**WEST SUSSEX COUNTY COUNCIL
STRATEGIC PLANNING CONSULTATION**

SUBJECT: EG/3/13/DOC

Application for details reserved by conditions 4 (stationing of vehicles) and 5 (replacement car parking spaces) following a grant of planning approval EG/9/07.

Commercial House, Fontwell Avenue, Eastergate, West Sussex

REVISION			
PROJECT		Proposed Development at Commercial House, Fontwell Avenue	
SUBJECT		Site Plan - showing proposed parking spaces	
SCALE	DATE	DRAWING No	
	Jan 2013	06 / 67 / 17	
DRAWN	CHECKED

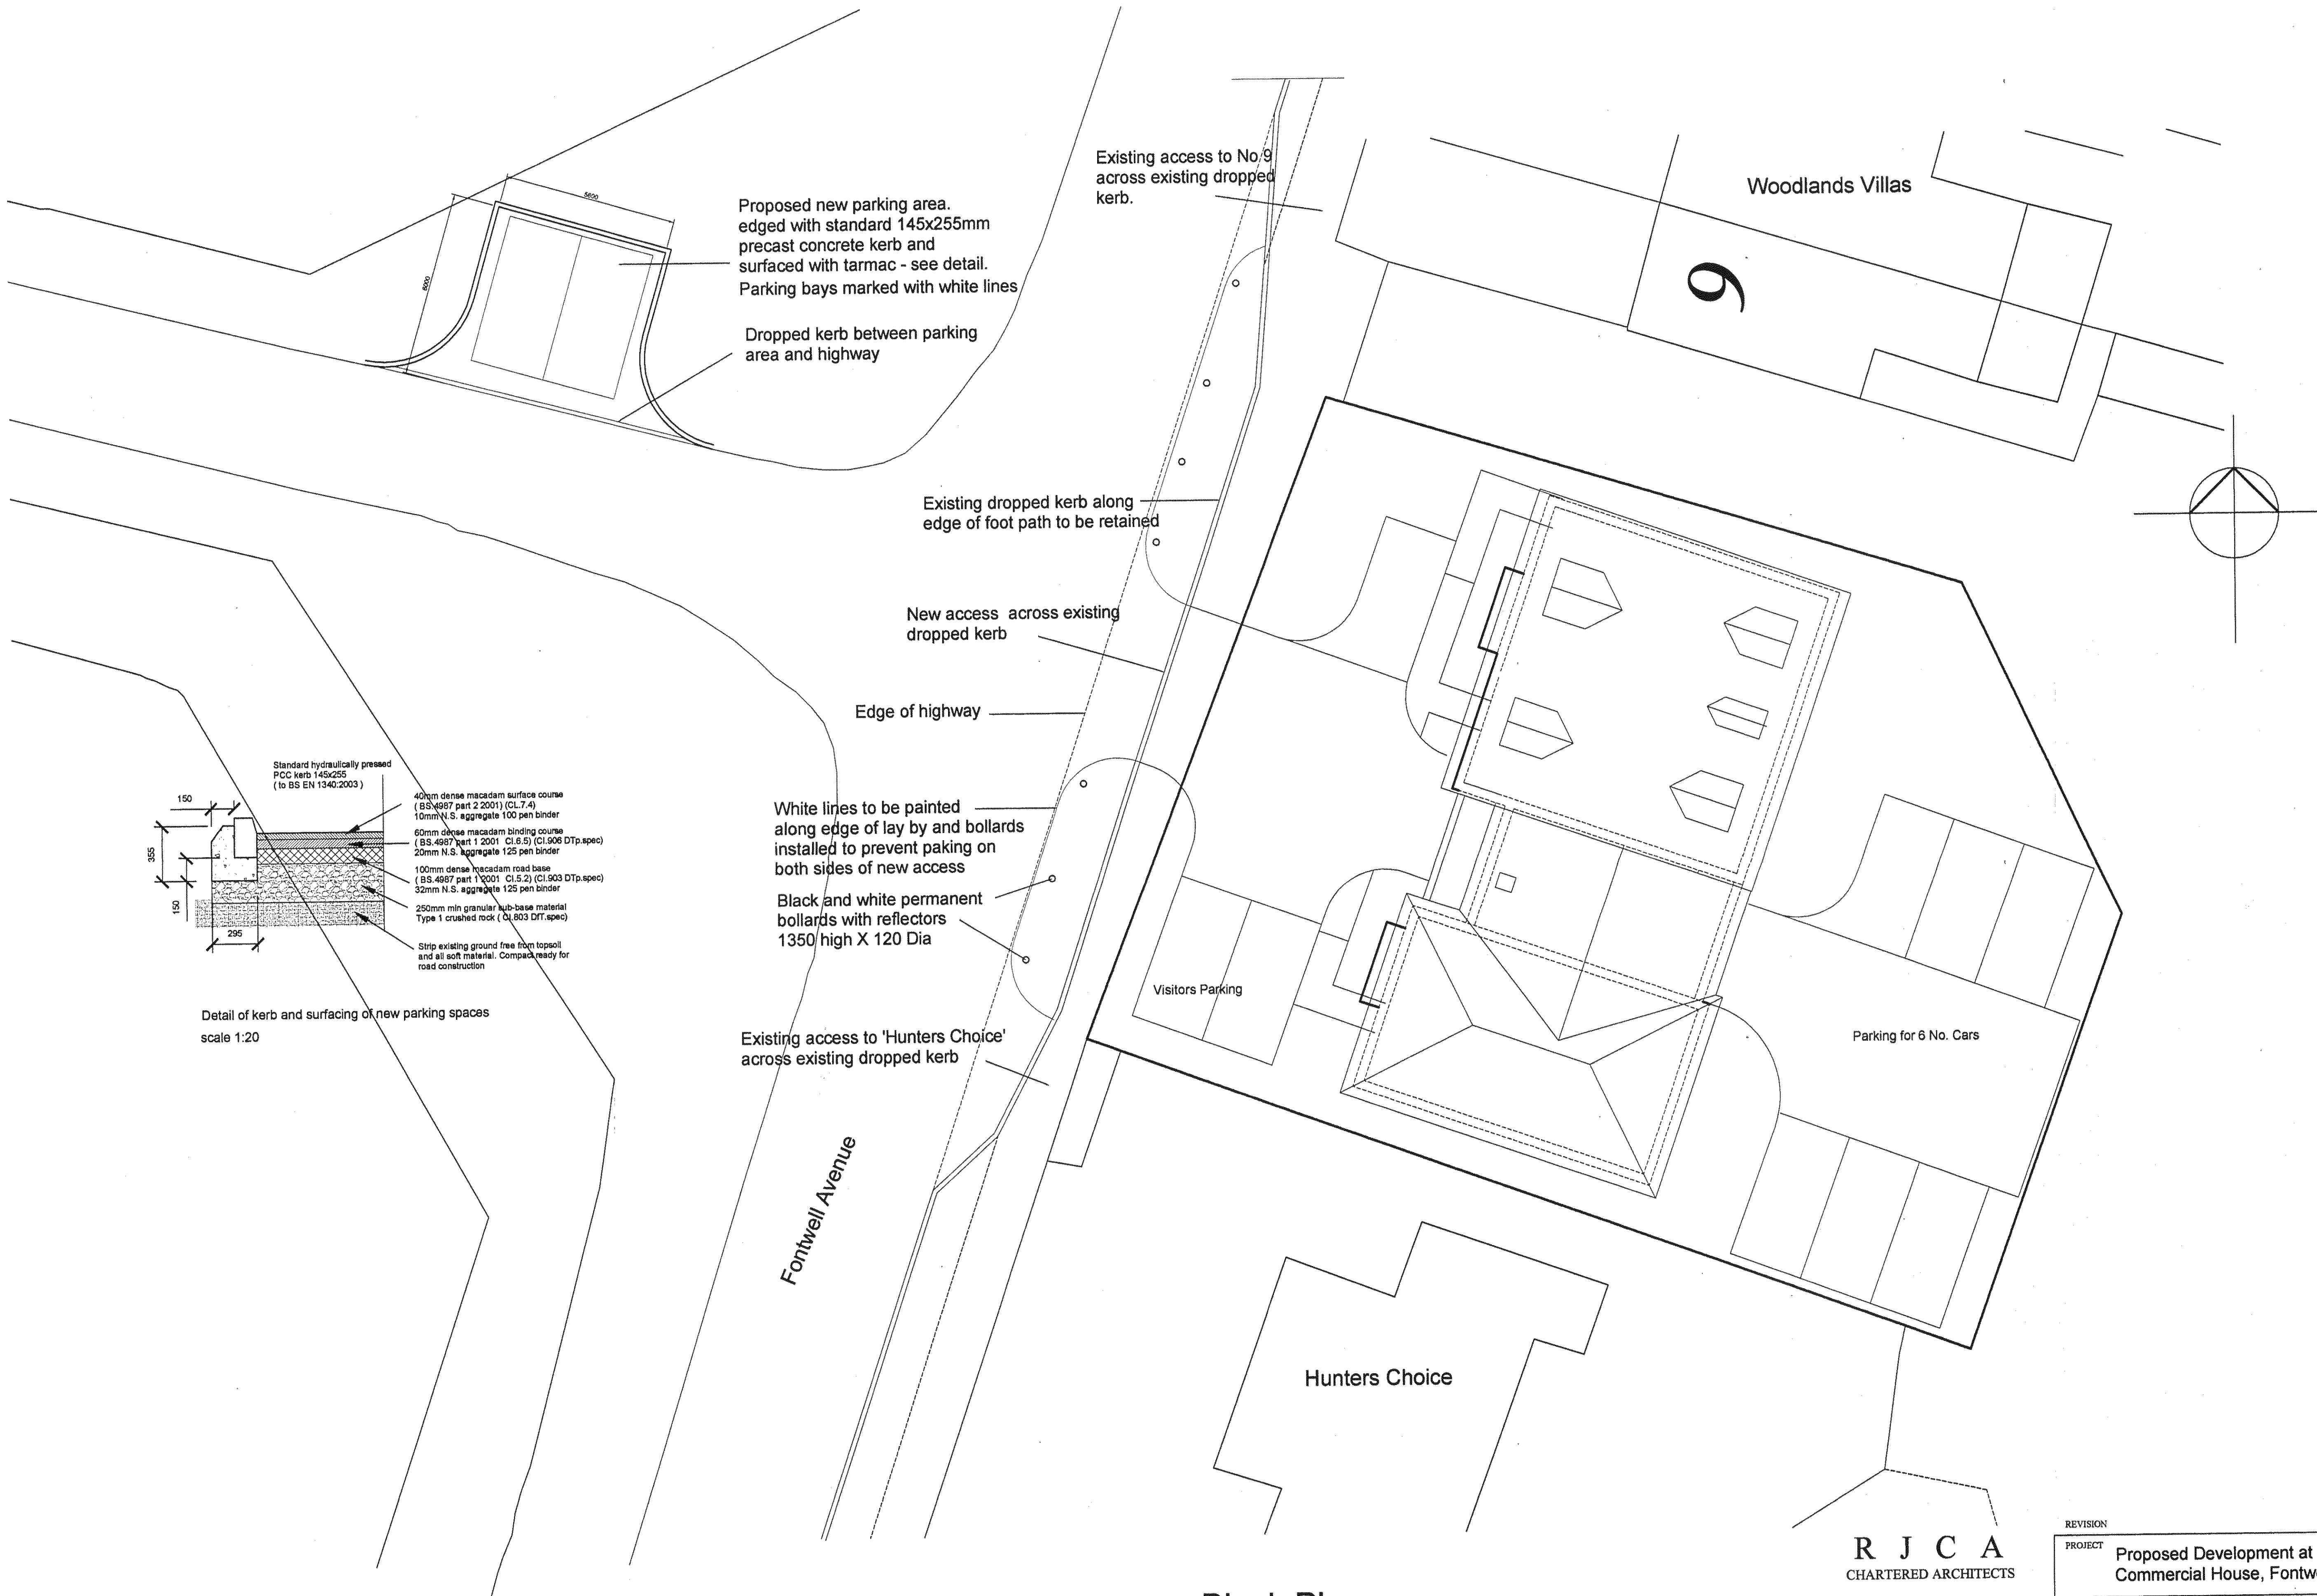
With respects to the details provided in connection with condition no. 4 & 5 of EG/3/13, WSCC agree in principal to the proposed car parking spaces submitted in drawing 06/67/17. However WSCC would advise that the Highway Authority's mechanism for checking the acceptability of works within the Highway is by the way of a Section 278 Agreement.

At present, my records do not indicate that the Applicant has made an application to enter into an s278 agreement, hence whilst the broad details have been accepted through the planning process; it would be premature to discharge this condition prior to the submission of an s278 application. The applicant is requested to contact The Implementation Team Leader (01243 642105) to commence this process. The applicant is advised that it is an offence to undertake any works within the highway prior to the agreement being in place.
